CITY OF ALBUQUERQUE

May 4, 2012

**Re: Tuan Van Huynh Residence Grading and Drainage Plan
Engineer's Stamp dated 04-13-12 (L-23/D001D)**

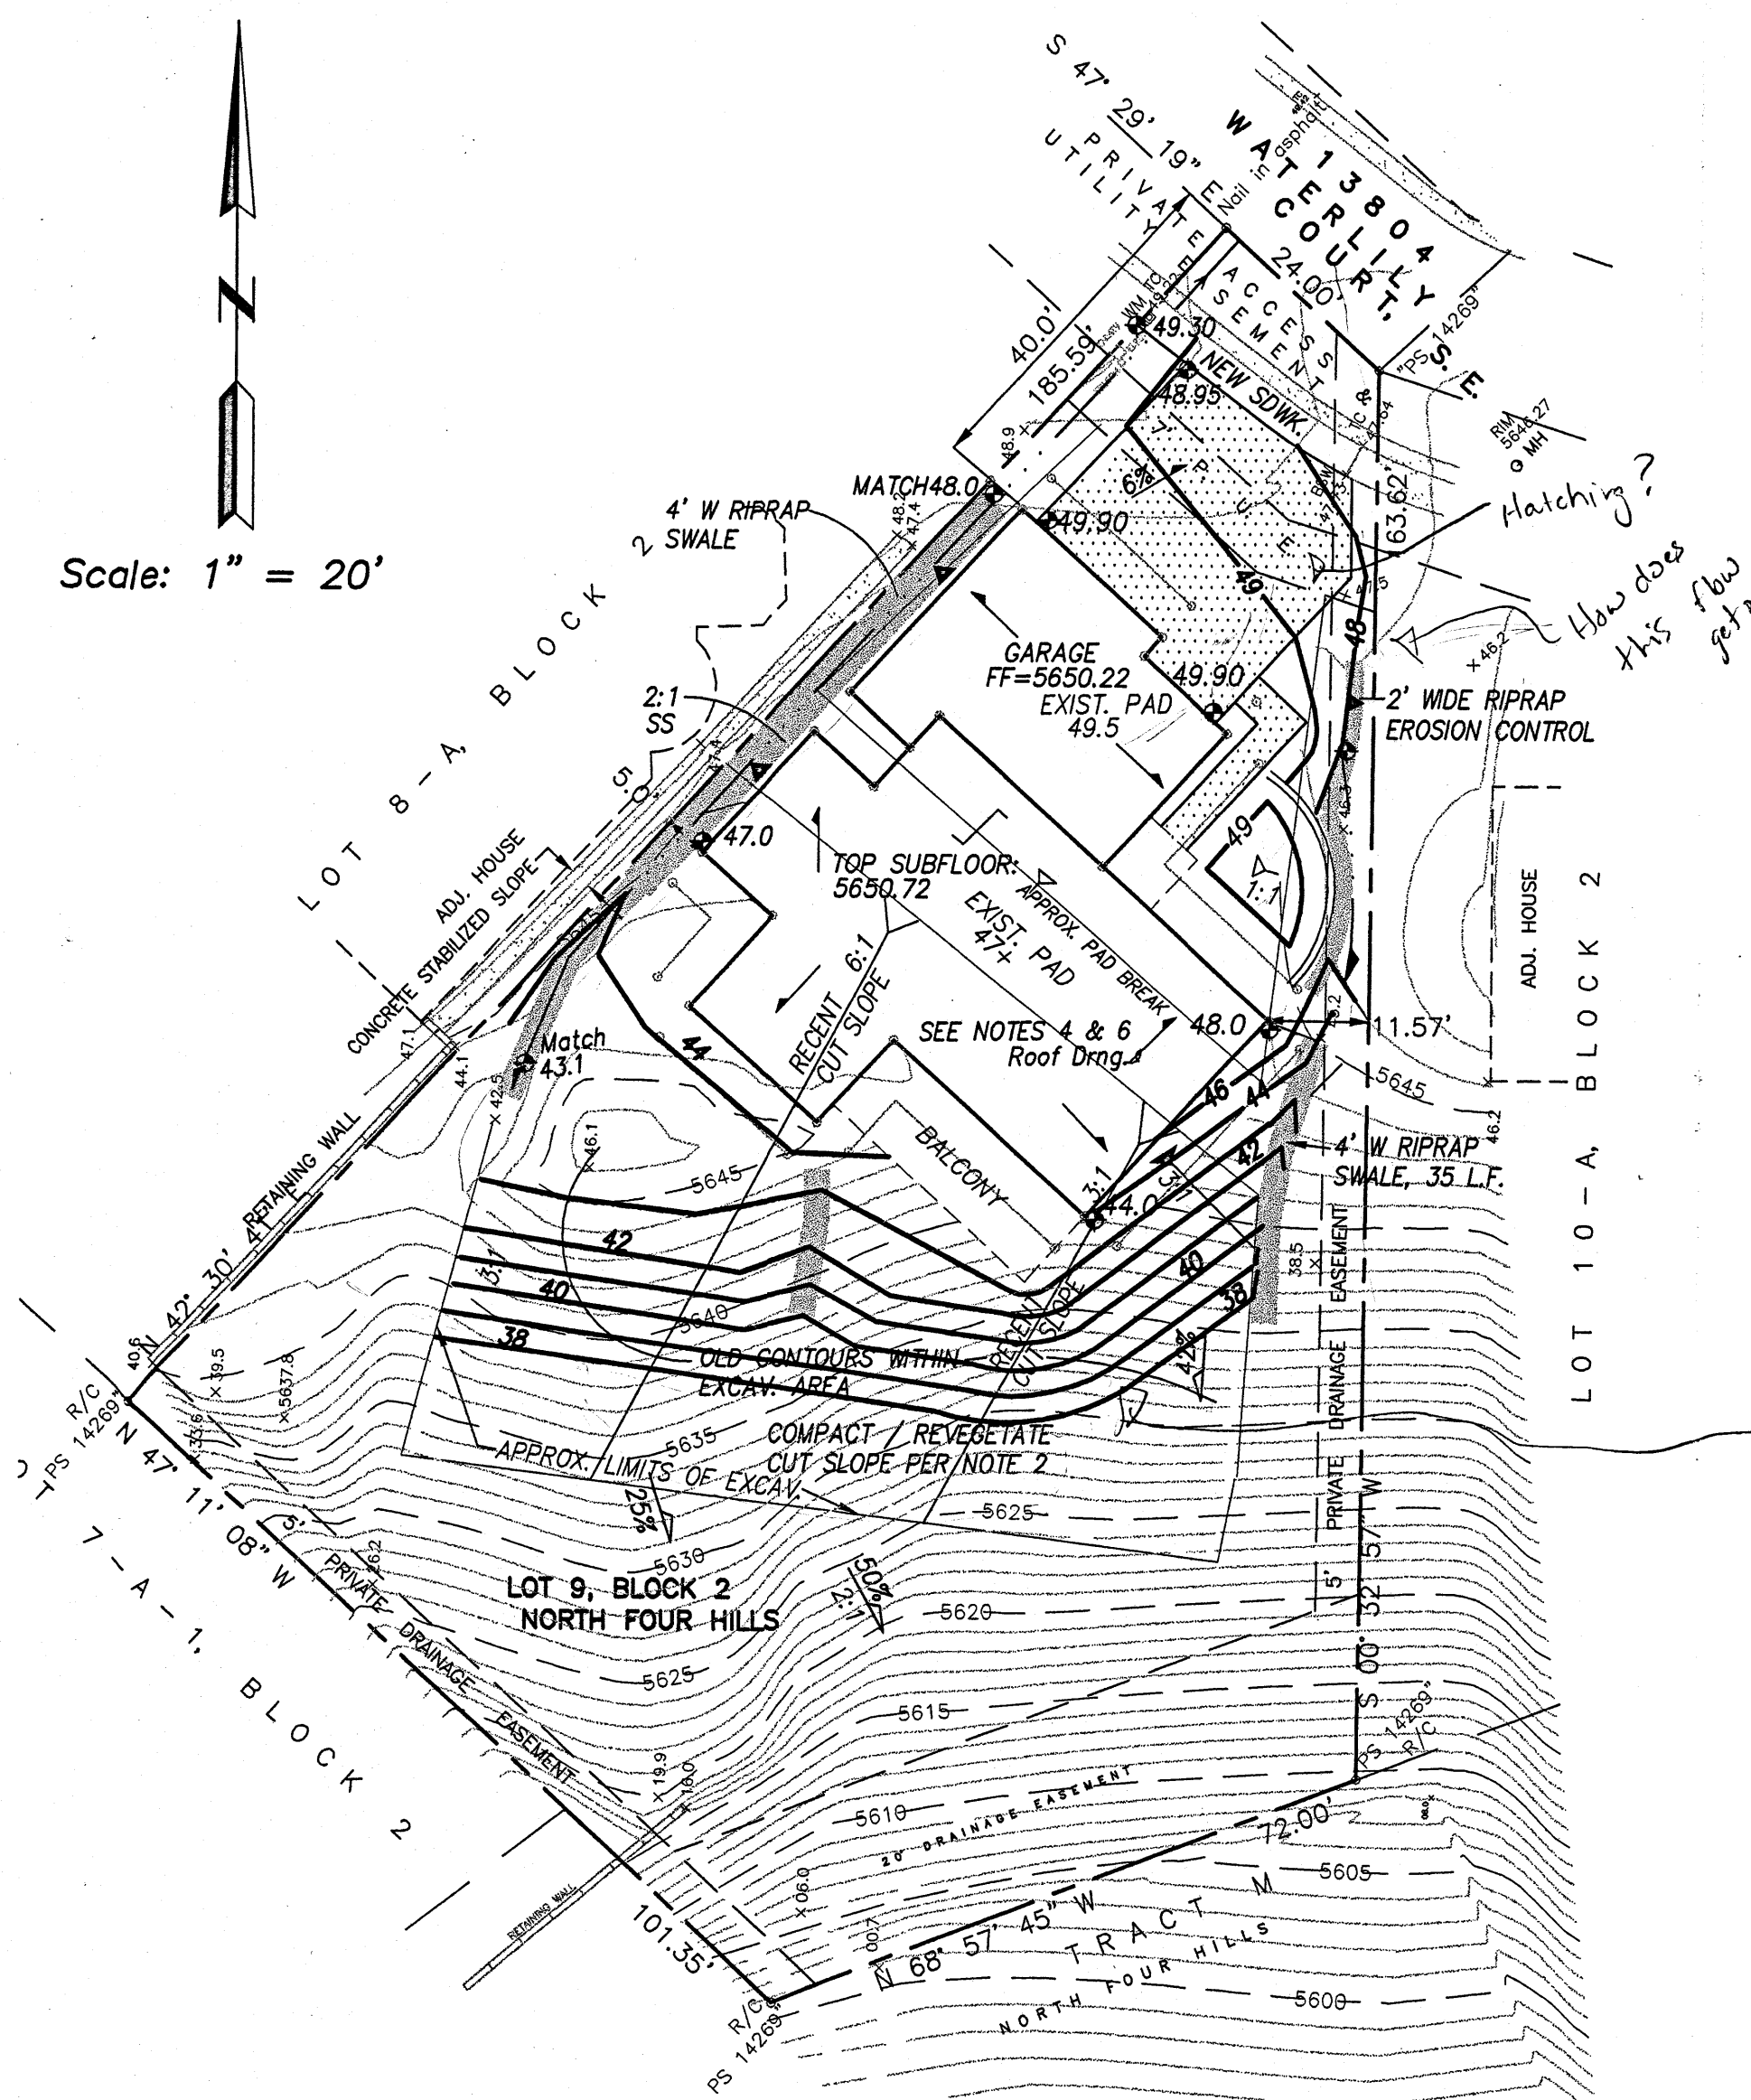
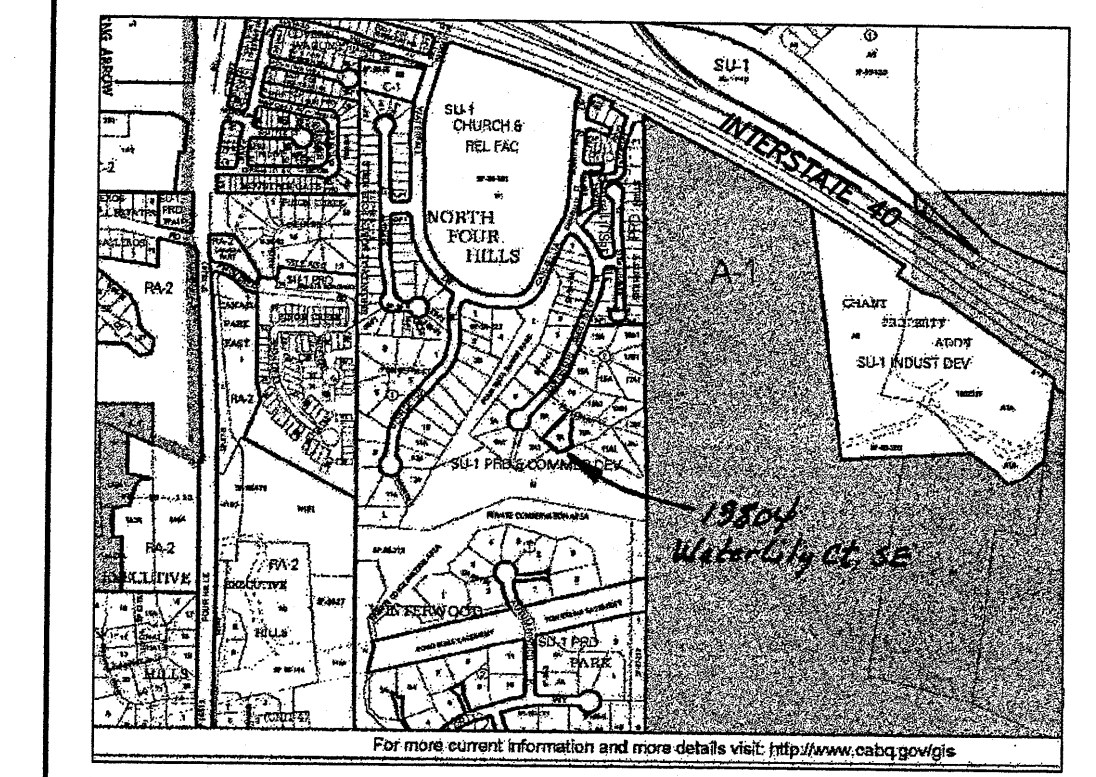
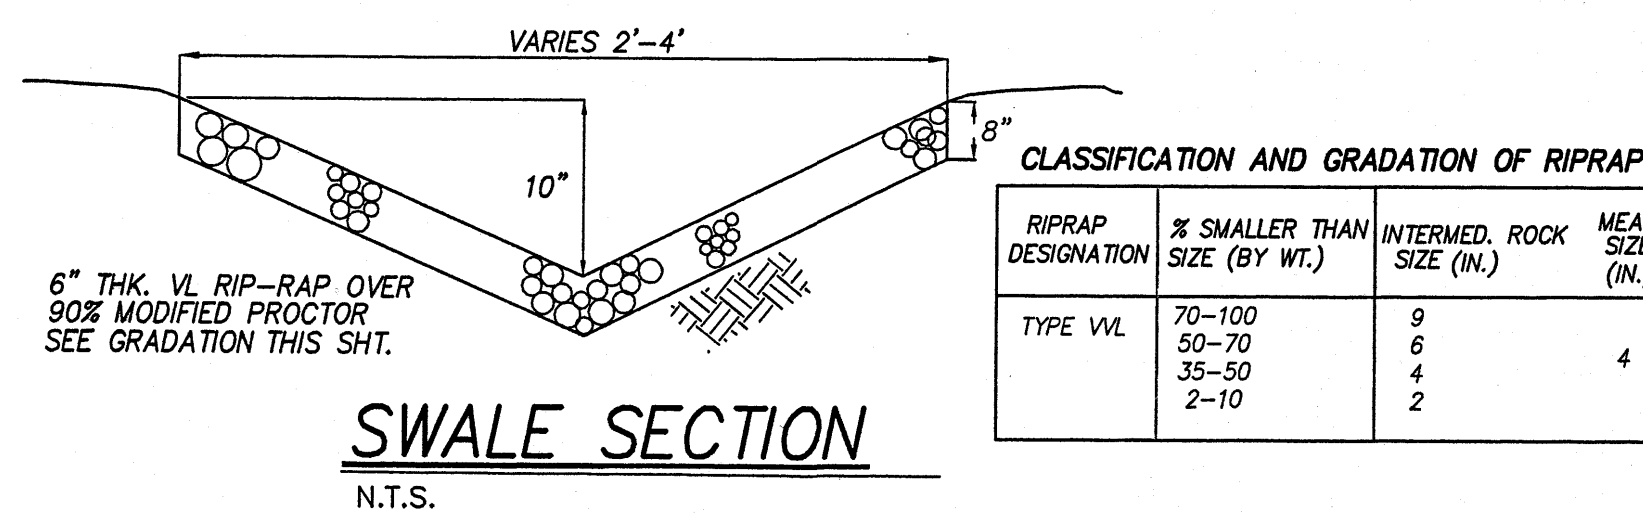
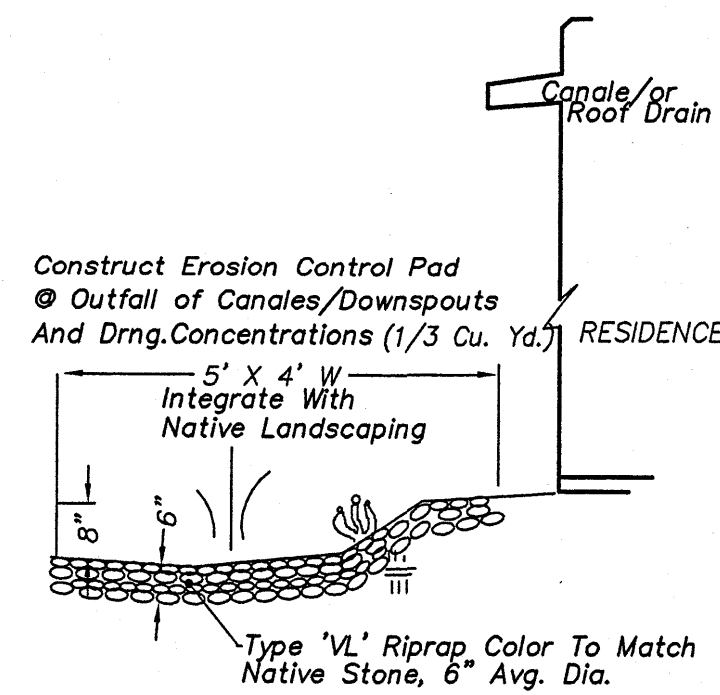
- Since the topography does not represent the exiting graded areas, as-built grades will be required.
- Slopes treatment will be needed for the slopes exceeding 3:1 grades.
- There is also an existing retaining wall within the 5' drainage easement along the southerly boundary. Need to make sure that this retaining wall will adversely impact the offsite runoff.
